Addendum No. 1

RE: Contract # C203825

Jackson County (R-4753)

NC-107 From North Of SR-1002 To NC-281

PROJECT REFERENCE NO. R-4753		SHEET NO. 9
RW SHEET NO.		
ROADWAY DESIGN ENGINEER	HYDRAULICS ENGINEER	
DOCUMENT NOT CONSIDERED FINAL UNLESS ALL SIGNATURES COMPLETED

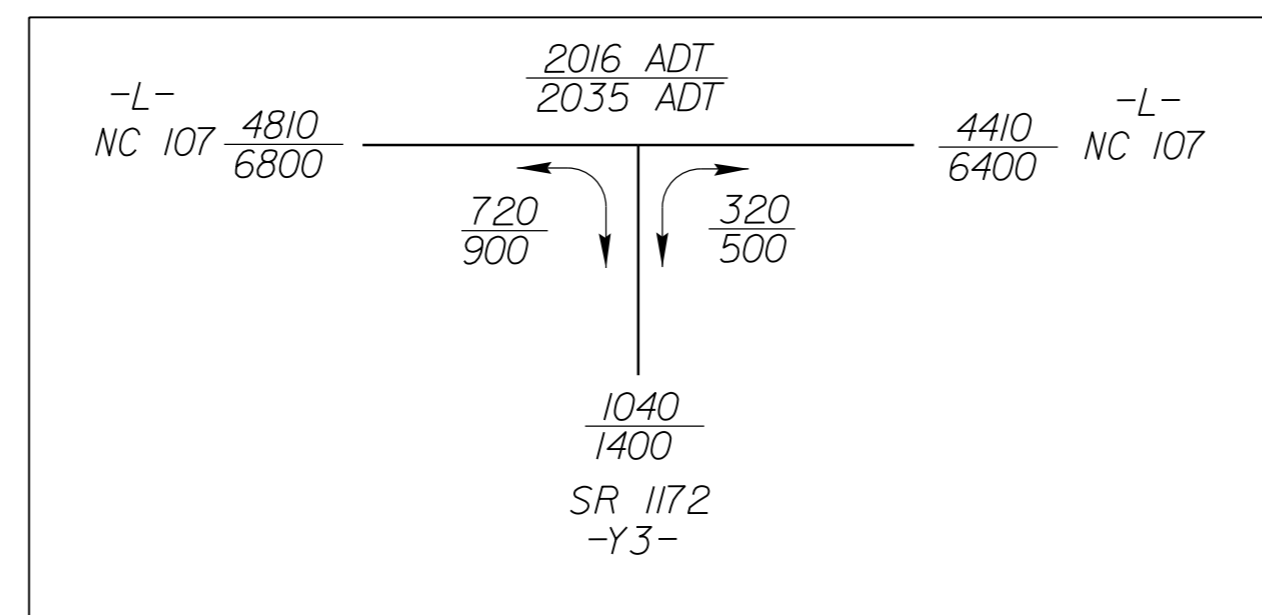
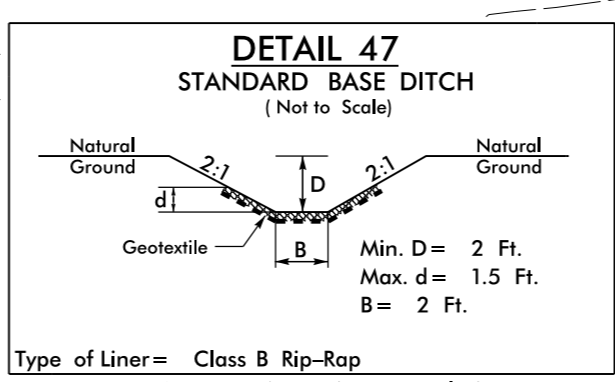
Sheet No.	Revisions
1	Revised the letting date on the Title Sheet
8, 9, 11, 12, 19 and 25	Revised or added a design exception note
